Recommendation Report for Approval of Reserved Matters Following Outline Approval

REF NO: BE/79/20/RES

LOCATION: The Cottage
Shripney Road
Bognor Regis
PO22 9PA

PROPOSAL: Approval of reserved matters following BE/63/17/OUT & variation of condition BE/131/18/PL for replacement dwelling at the southern end of site (Phase 1) to reposition driveway & car port (resubmission following BE/58/19/RES).

Drawing Title
Proposed Plans & Elevations
New Dwelling

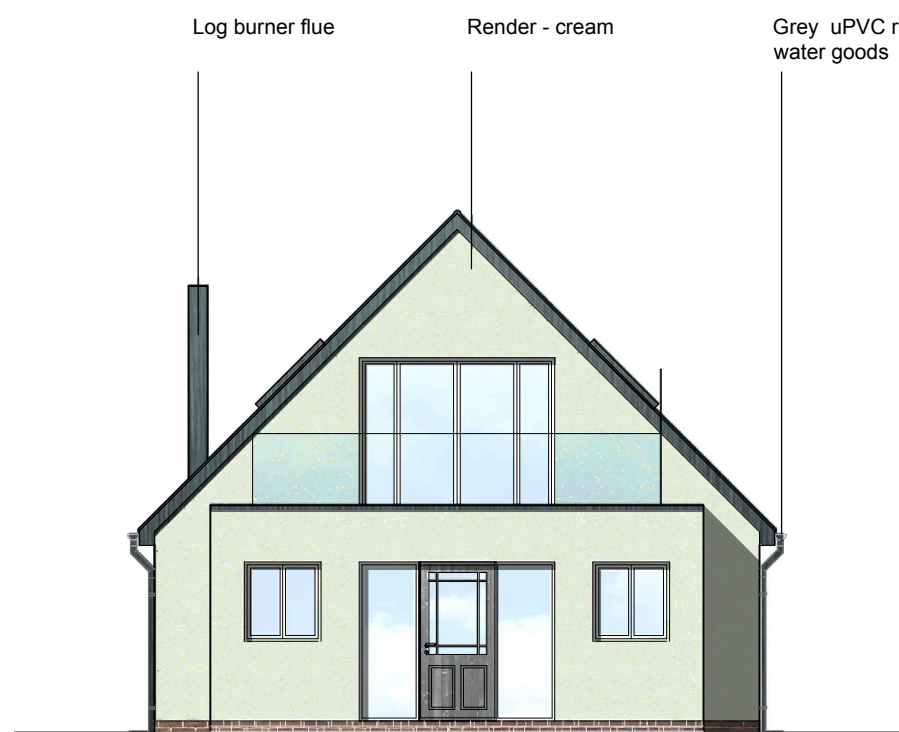
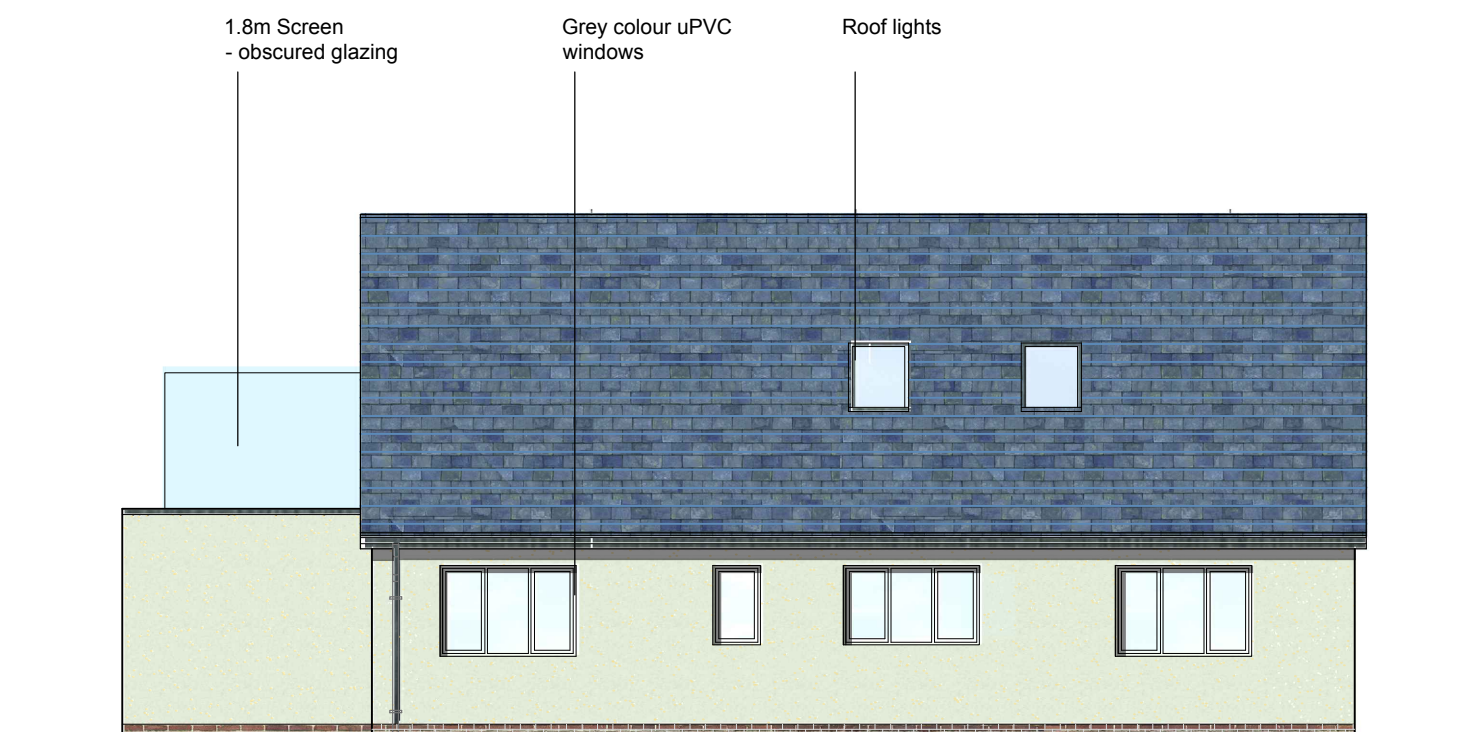
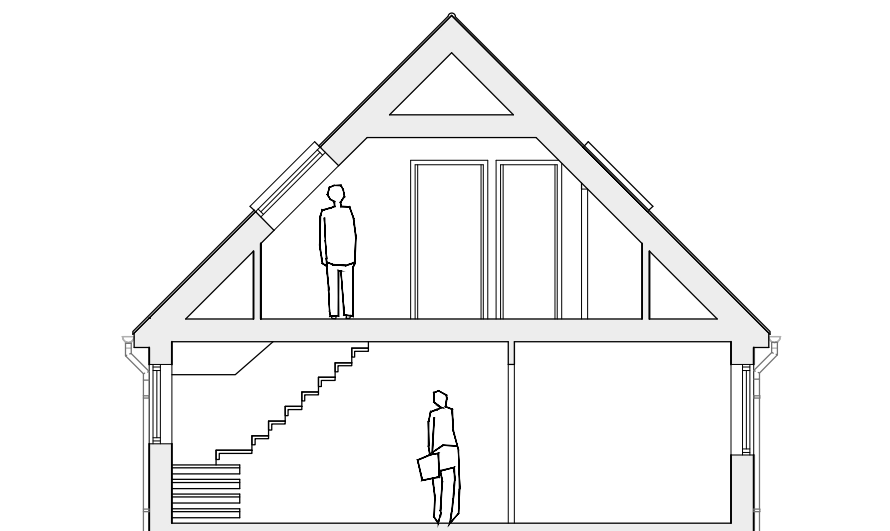
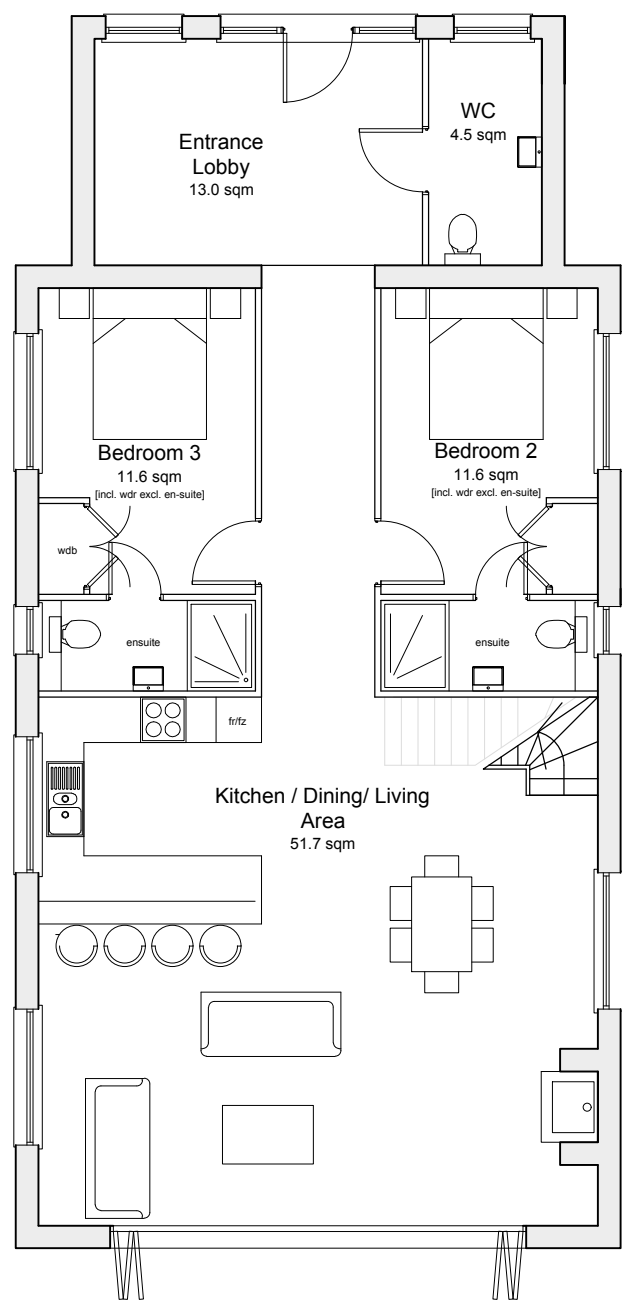
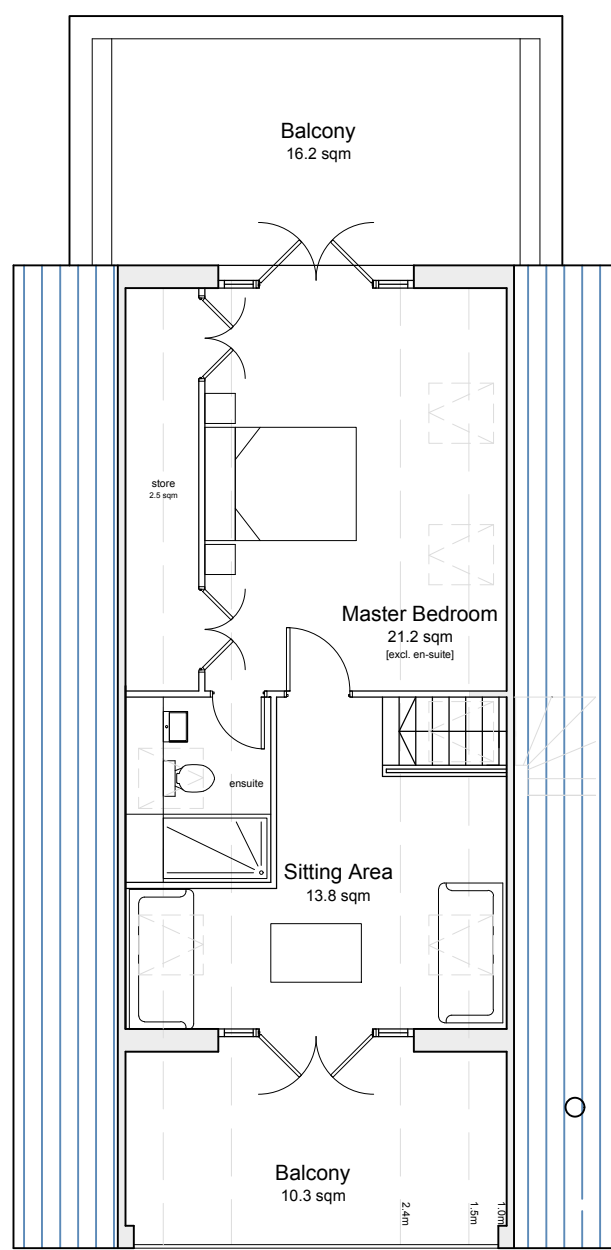
There will be no significant harm to the amenity of Royce Cottage from the layout as the dwelling is to the north of Royce Cottage and there is existing tree and hedge screening to the shared boundary and also a long single storey outbuilding on Royce Cottage's side of the boundary. The new house will have velux windows in the roof plane facing Royce Cottage and there will also be a balcony to the front which could allow views towards Royce Cottage. A condition will be added to require that these two velux windows are obscure glazed. A further condition will enforce the side screen shown on the plans which will prevent views being gained towards and over Royce Cottage's property. Lastly, permitted development rights will be removed for dormer windows in the southern roof plane.

- 7 The front balcony hereby approved shall not be used until the 1.8m high obscure glazed glass side screen has been installed in accordance with the drawing "Proposed Plans and Elevations New Dwelling" ref 6656-001 Rev D. The screen shall thereafter be permanently retained in perpetuity.

- 8 The two velux windows on the southern roof plane of the building shall at all times be glazed with obscured glass.

Site Plan
1: 200

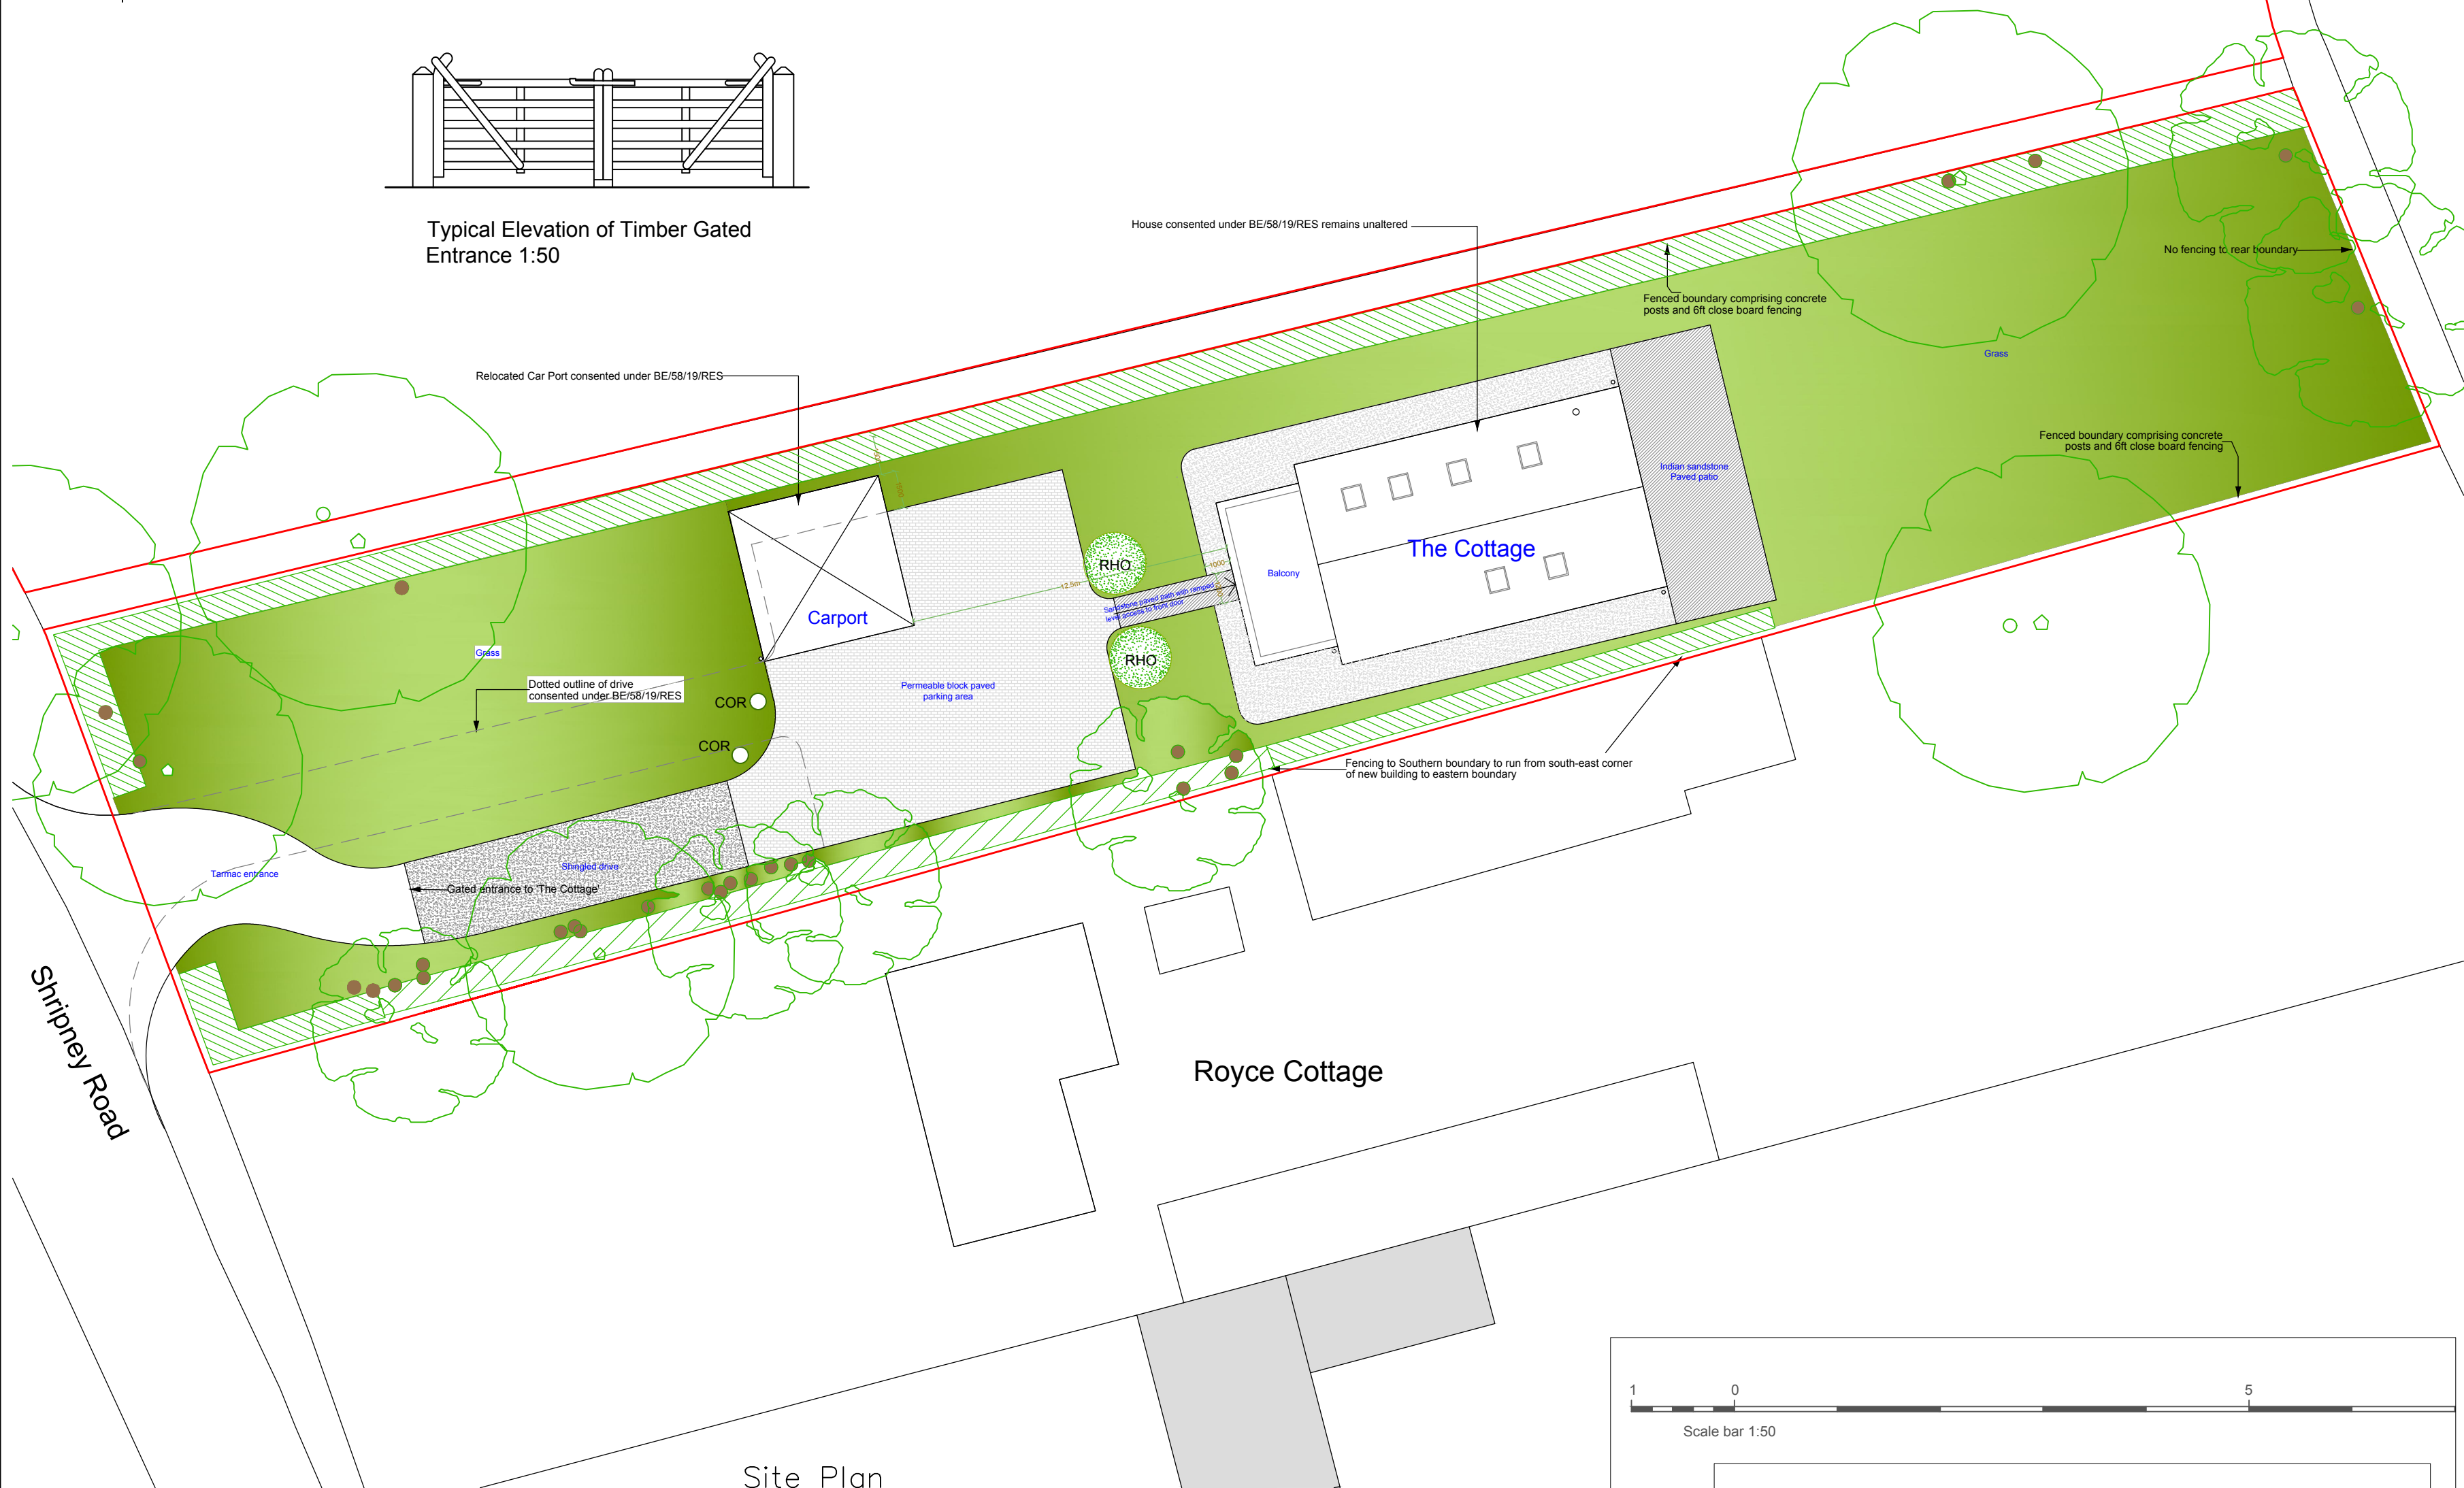
"No objection but comment that the gate to the driveway should be set far enough back for vehicles to access without protruding onto the A29."

"Raise no concerns with the application. State that if gates are being installed these should be set back from the highway to allow a vehicle entering the site to wait clear of the highway, while they are being operated. Also no boundary treatment above 600mm should be installed at the access point to obstruct pedestrian visibility and the visibility of a vehicle leaving the site to see pedestrians. Request conditions to secure cycle parking, pedestrian visibility and the car parking spaces. Also ask that a highway works informative be added."

The plans show the gate to be almost 12m from the edge of the highway and it is noted that WSCC Highways raise no concerns with these arrangements.

WSCC Highways have no objections to the application including the position of the gate on the driveway and the scheme is considered to comply with these criteria. The changes to the driveway are not considered to materially alter the previous views expressed regarding road layout. It is not known what arrangements there will be for refuse collection but a refuse lorry could either collect from the roadside as is likely for existing properties or possibly back into the site and depart in a forward gear. There is therefore no conflict with policy T SP1 in respect of road layout.
